June 30, 2017

Ms. Helen Donaldson
City of Portland Planning Authority
4th Floor, City Hall
389 Congress Street
Portland, ME 04101

**RE: AC Hotel Portland
Plan Set Revision Summary**

Plan Set Sheet Revision / Update Summary

Sheet No:
L2.1
Sheet 1 of 00

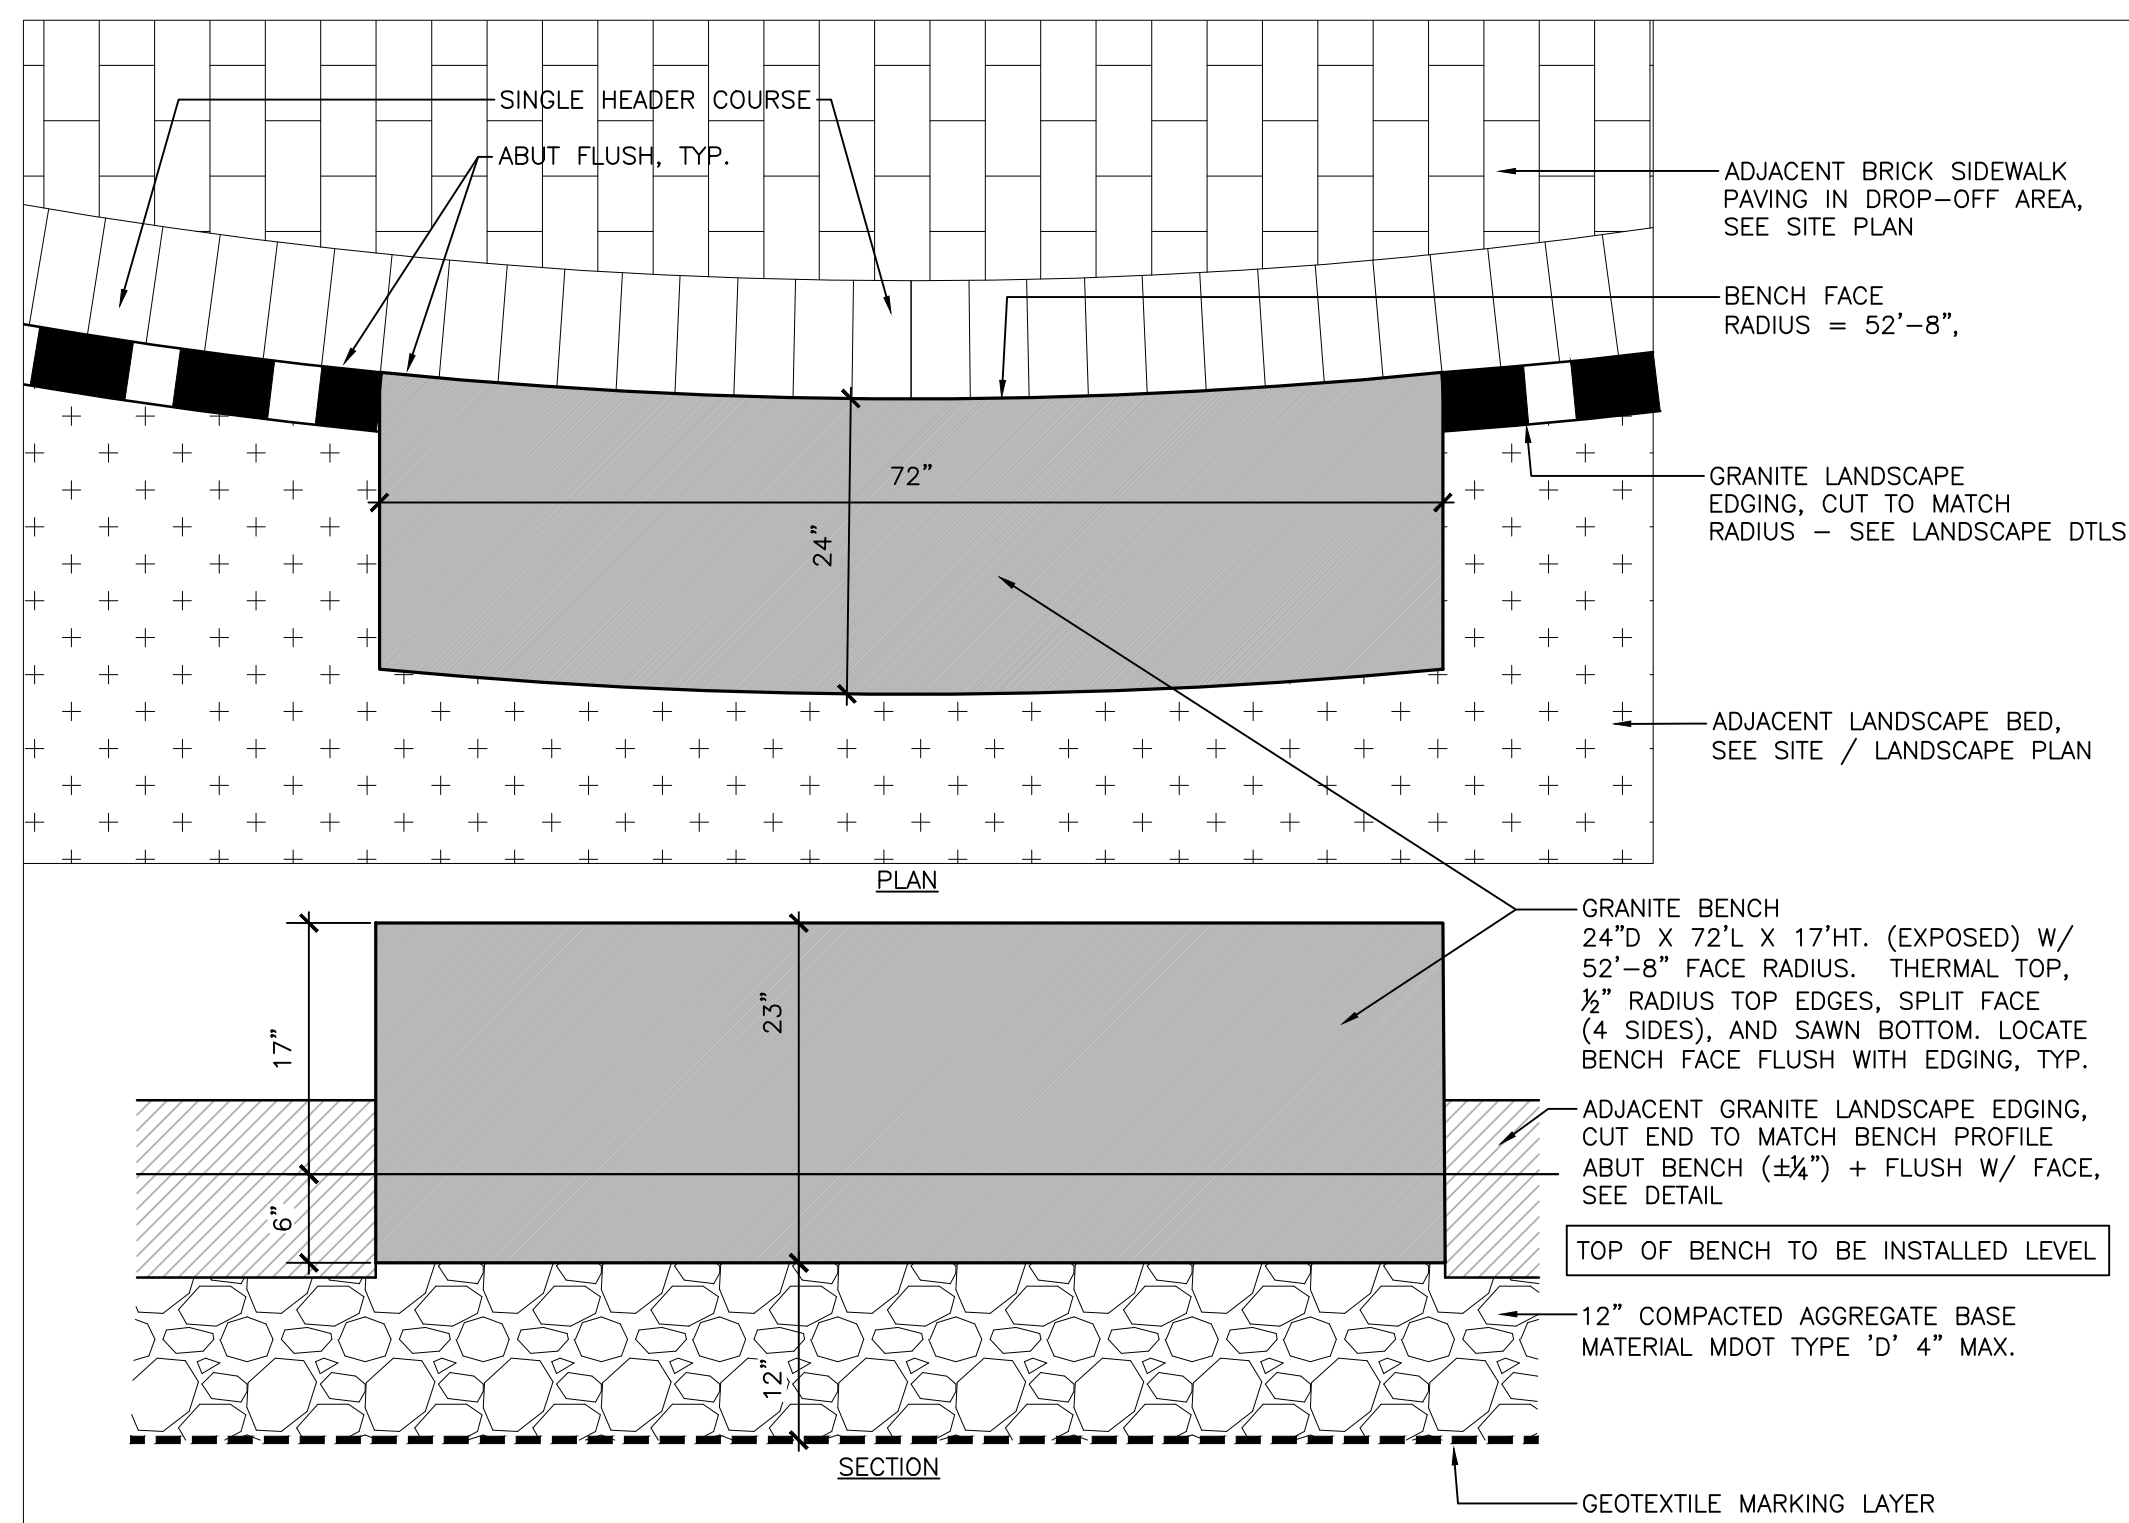
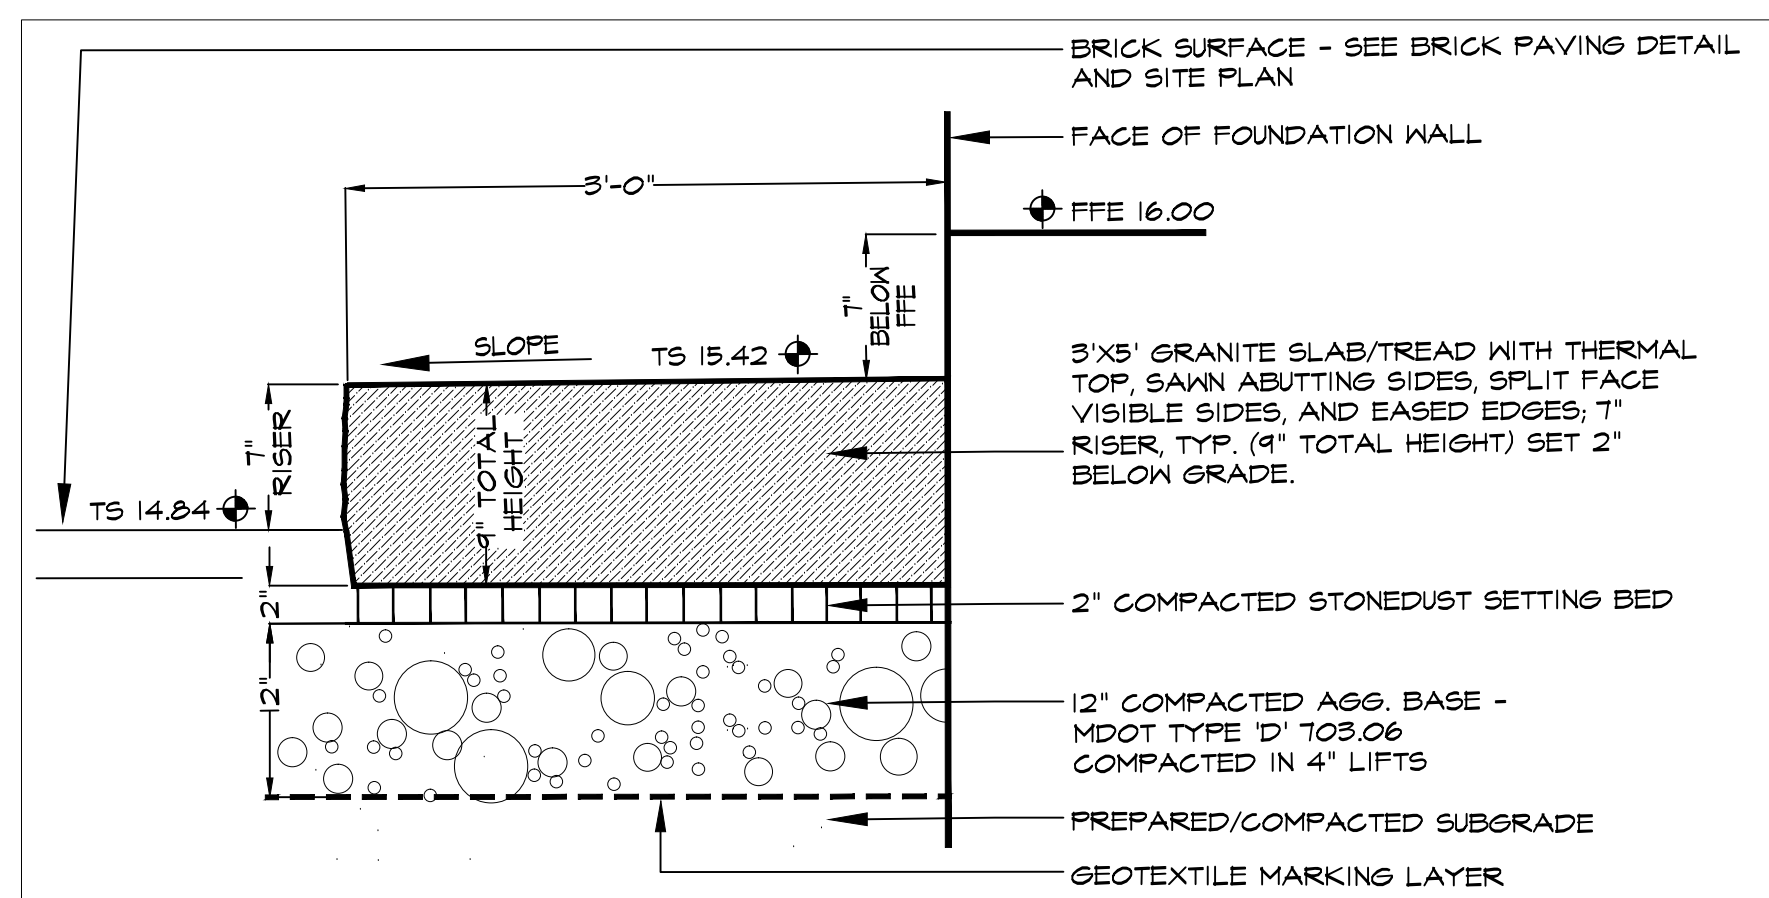
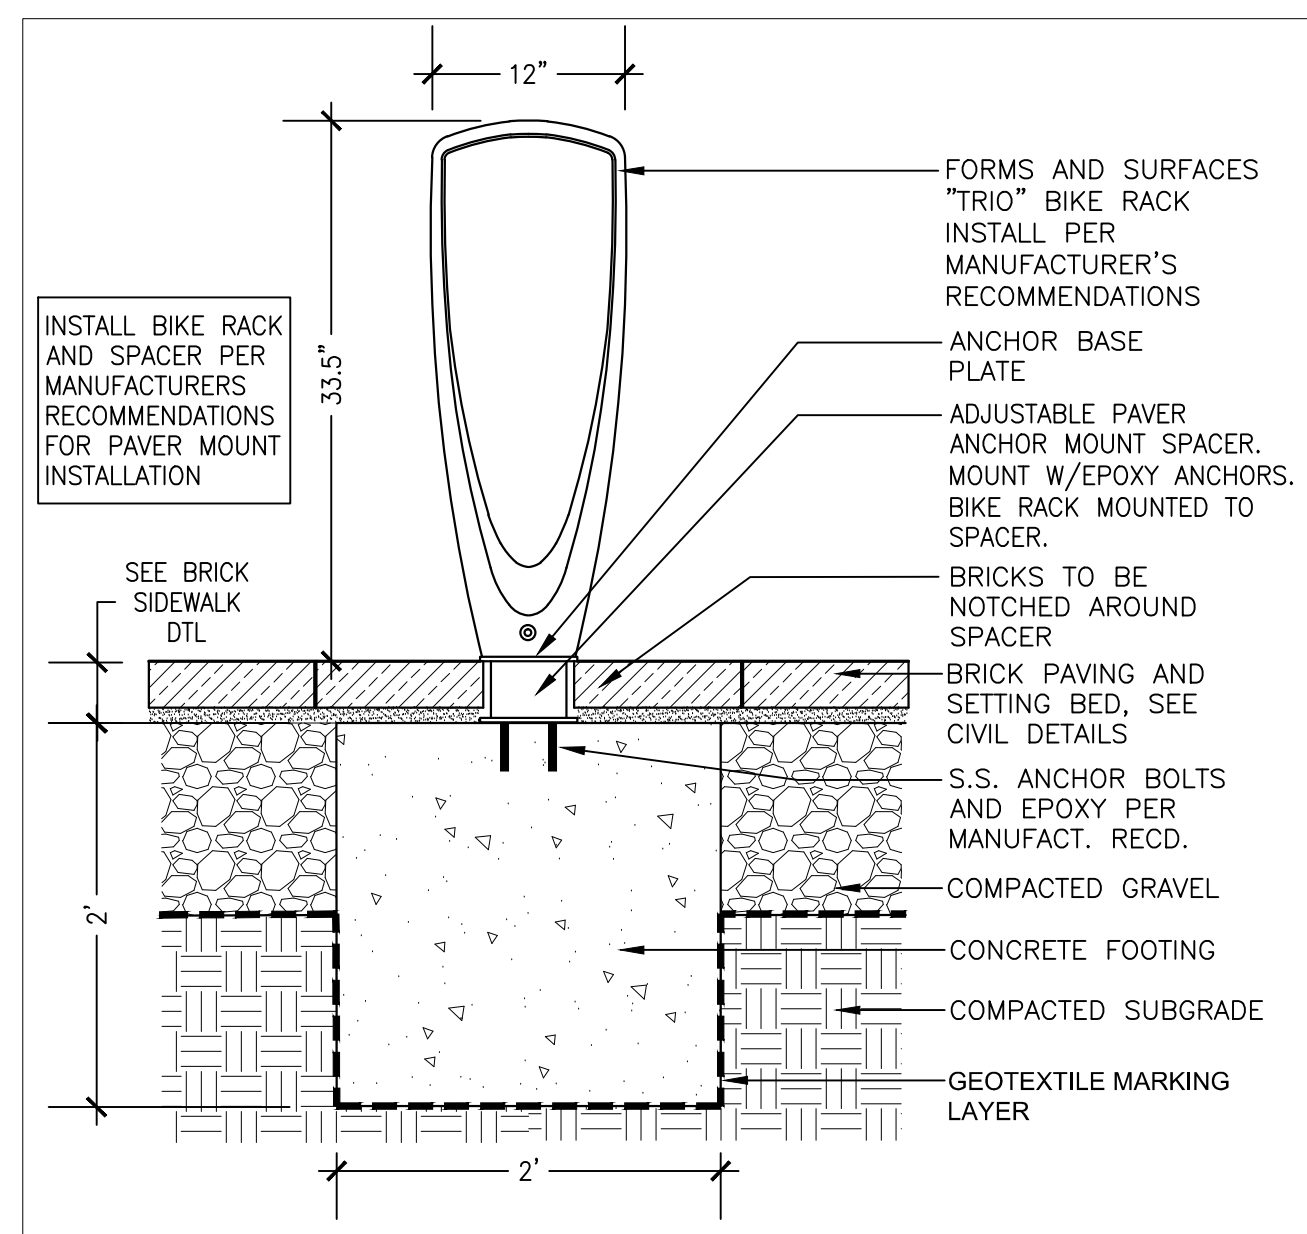
Revisions: Update Thames Street steps and handrail detail. Add Thames Street granite seatwall details. Update granite bench finish info and shape.

Revisions: Add light bollard installation details (2) and street light installation detail.
